Our reference: ECM: 9243201
Contact: Gavin Cherry
Telephone: 02 4732 8125

20 August 2020

Response to Request for Advice regarding Oakdale West Estate MOD5 SSD 7348

Figure 1: Concept Proposal Layout (MOD 5)

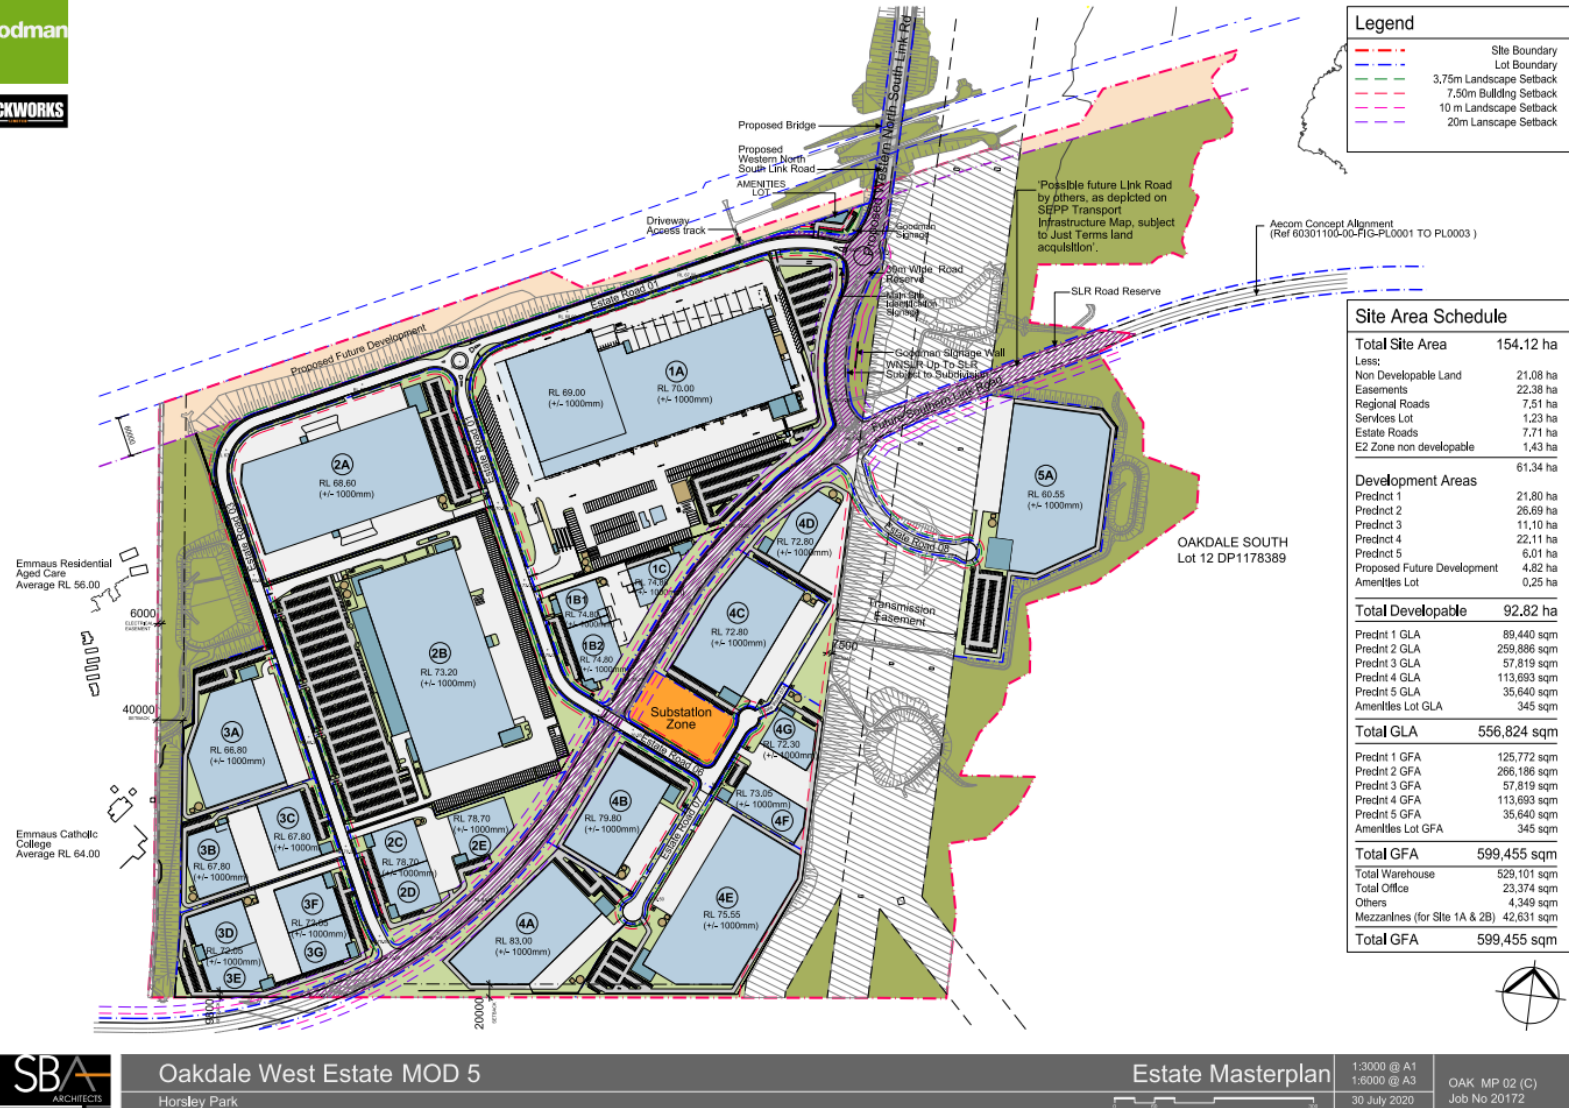
These requested changes will result in impacts to the developable areas of the adjoining proposed allotments (Proposed Lot 101 and 108) which will also have implications for the approved development being landscaping, car parking and potentially built form arrangements under SSD 7348. The required widening of the link road reserve / corridor will encroach into the landscaped batters that were previously approved for the industrial subdivision. Possible retaining walls may be required along sections of the new road reserve boundaries when the new Southern Link Road is constructed. As the final design for the SLR has not been determined, it is difficult to determine the future height of any retaining walls that will be required and this is critical to consider the impacts and implications of the development on the streetscape.

- Road reserve boundaries along the SLR near the intersection of the WNSLR (sheet C2020) will likely remain unchanged with batter slopes of 1 in 5 (SLR slopes down to Lot 1A).
- Where the SLR road reserve is widened into the batter adjoining the car park at the at the southern end of Lot 1A, the existing batter slopes of 1 in 3 will require either steepening or a retaining wall to support the SLR (sheets C2019 & C2020 – SLR slopes down to Lot 1A).
- The batter from Lot 1B down to the SLR is generally at 1 in 10 to 1 in 12 (Lot 1B slopes down to SLR). Widening of the road reserve boundary will require trimming and steepening of these batters to accommodate the SLR.
- The widening of the SLR road reserve adjoining Lot 2B west of Road No 1 (sheets C2030 & C2023) will also impact batter slopes within this area. Details have not been provided.

The proposed plans submitted in support of the Mod 5 application, as a consequence of required changes to the proposed lot configurations, are not suitable and require further amendment due to further widening required by TFNSW. Noting that lot dimensions for road reservation widening is required, this widening cannot be at the expense of the landscape setback approved in the above SSD determination. Where the landscaping setback is impacted to less than the minimum 10m approved, reconsideration and amendment of the overall development arrangement is considered to be necessary.

As raised in Council's comments as part of the preceding assessment, the retention of Proposed 102 with 2 x warehouse developments was considered to reflect an overdevelopment of the site that ideally should have been amalgamated into a single development lot. Any required widening of the link road as part of the separate subdivision development application that reduces landscaping to less than 10m, would suggest the need again, to delete Lot 102 (or reduce Lot 102 deleting Warehouse 1C), and relocate all approved parking that encroaches into the revised 10m landscaped setback zone into this part of the site.
